Emailed January 7, 2021
DRB Comments for Meeting on 1/13/2021

From: Nicole M. Friedt, P.E., Development Review Engineer
AMAFCA

RE: DRB COMMENTS for PR-2018-001579

SI-2020-01477

DRAWN BY	
REVIEWED BY	
DATE	12/11/2020
PROJECT NO.	20-0161.001
DRAWING NAME	CONCEPTUAL GRADING PLAN

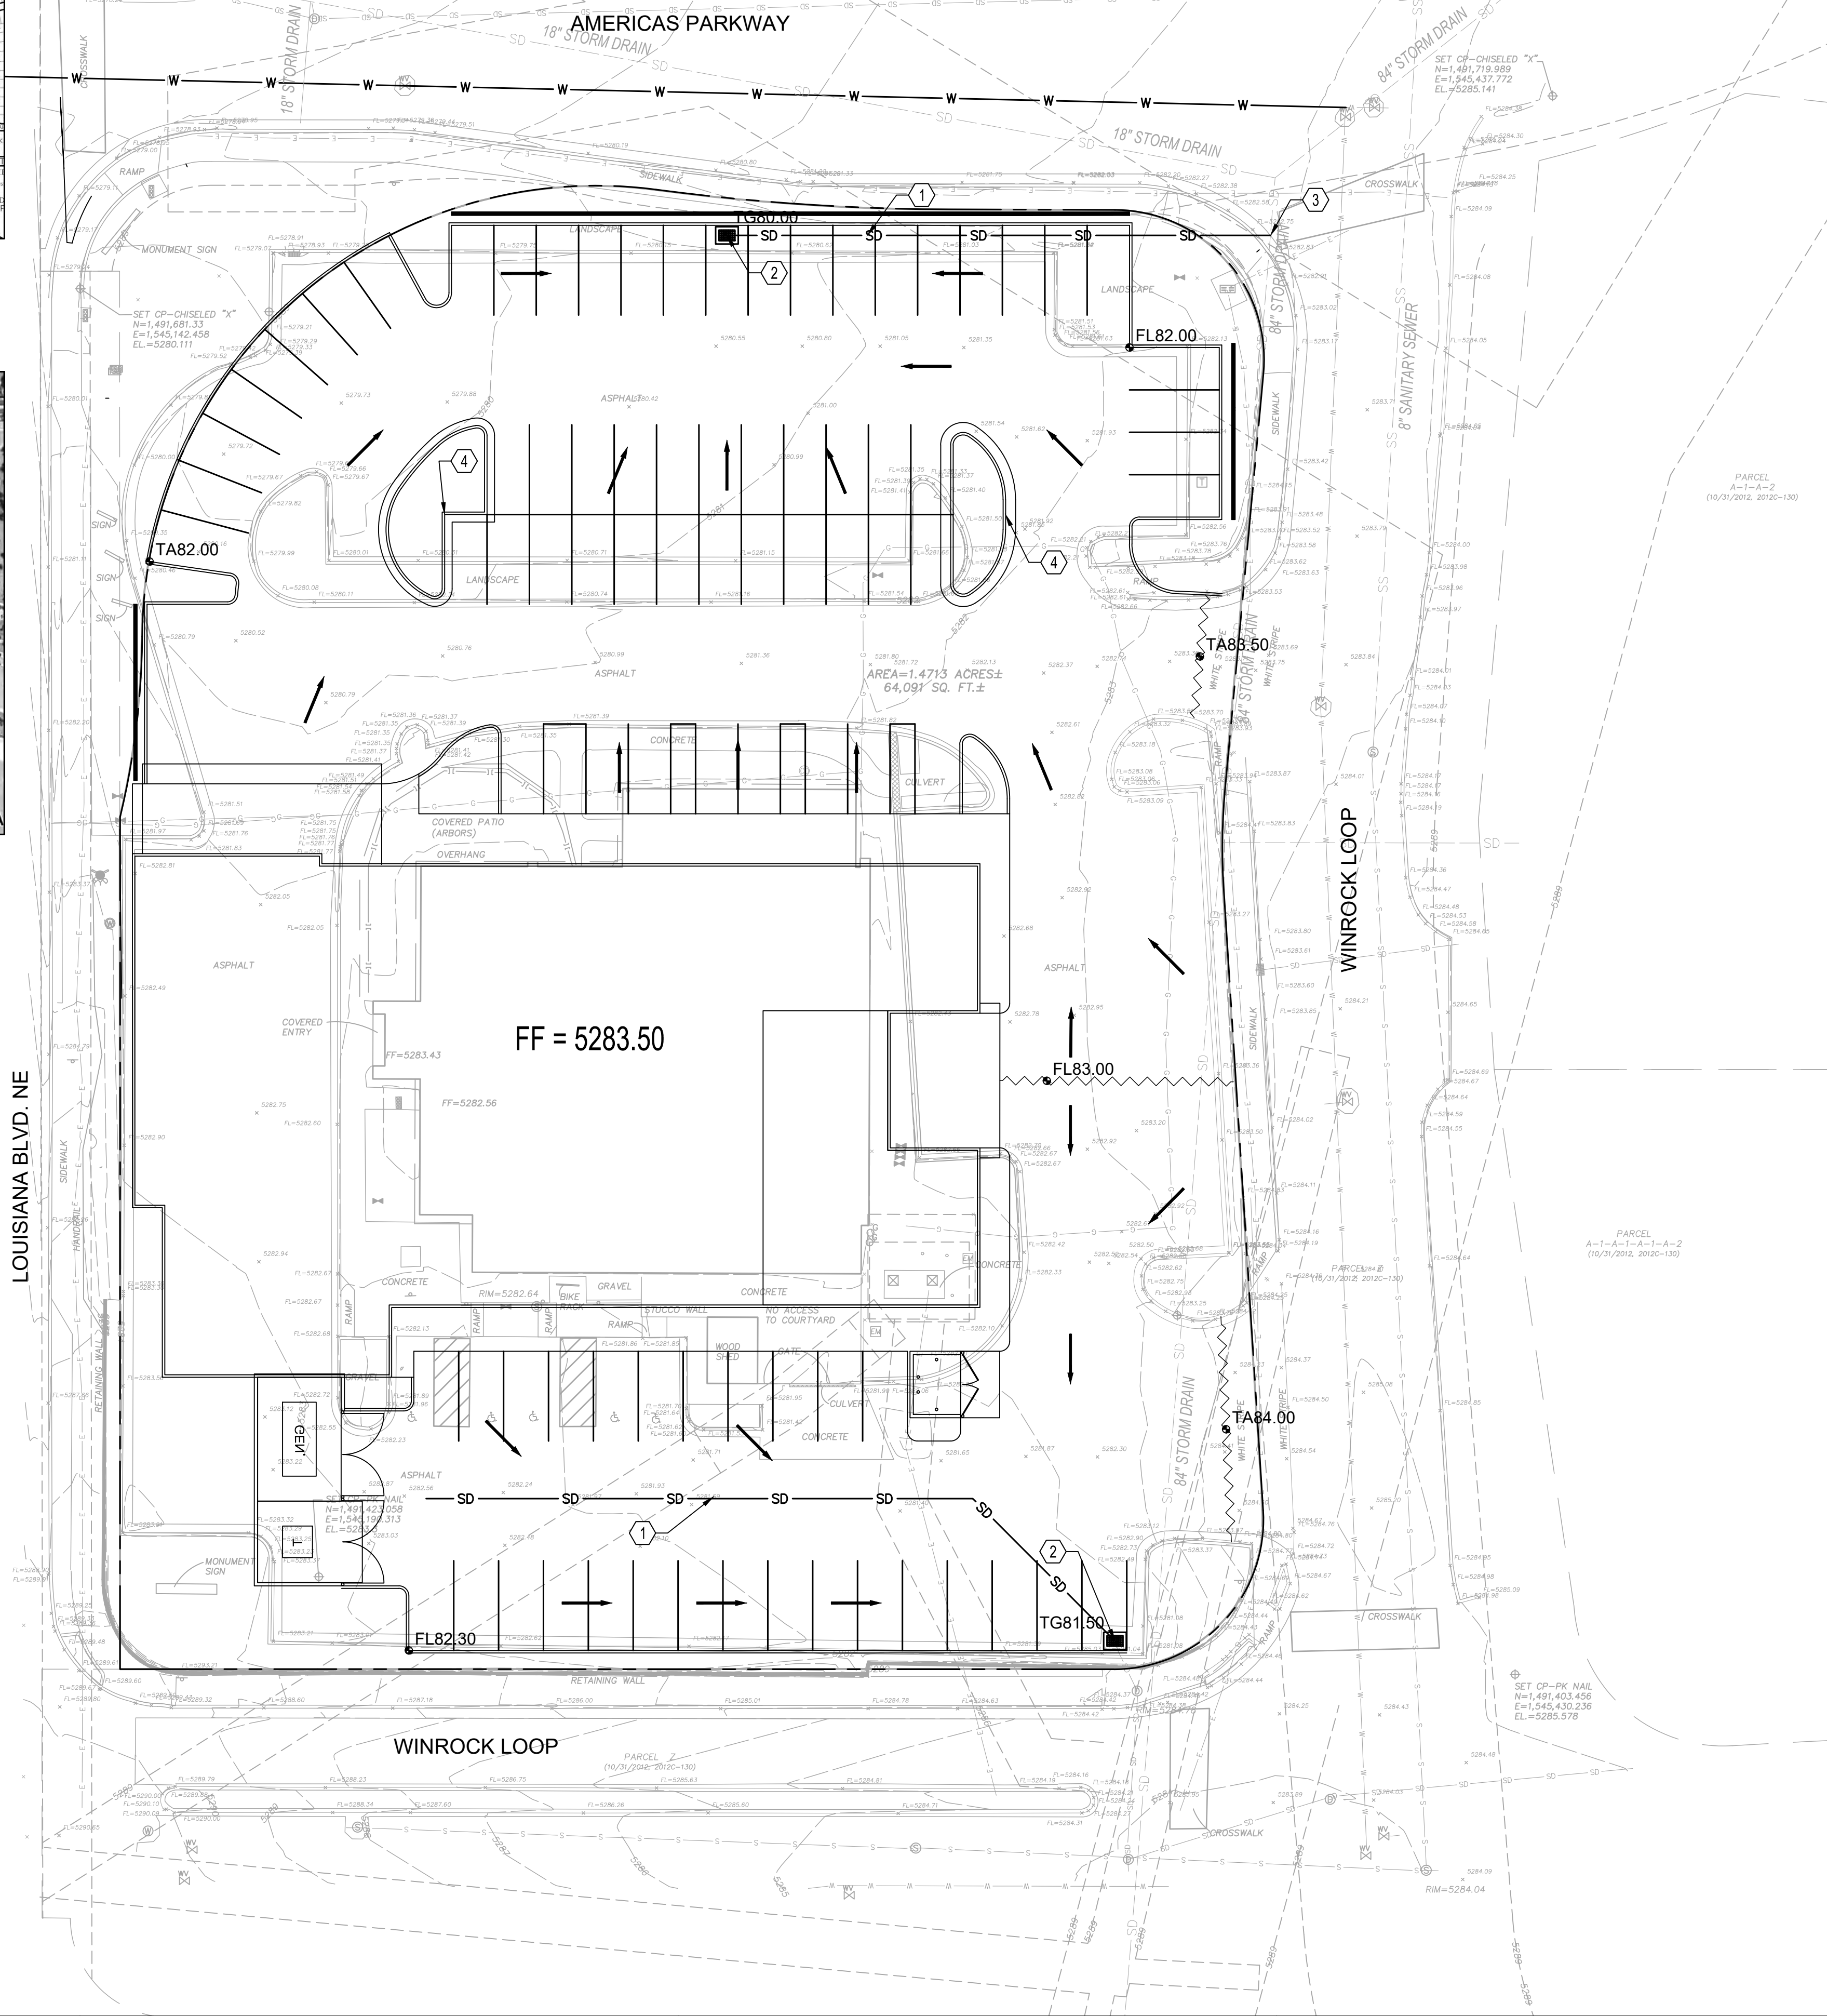
- Please clearly state on the Drainage Plan if the proposed site plan results in runoff that is consistent with the DMP's allowable flow rate from this site.
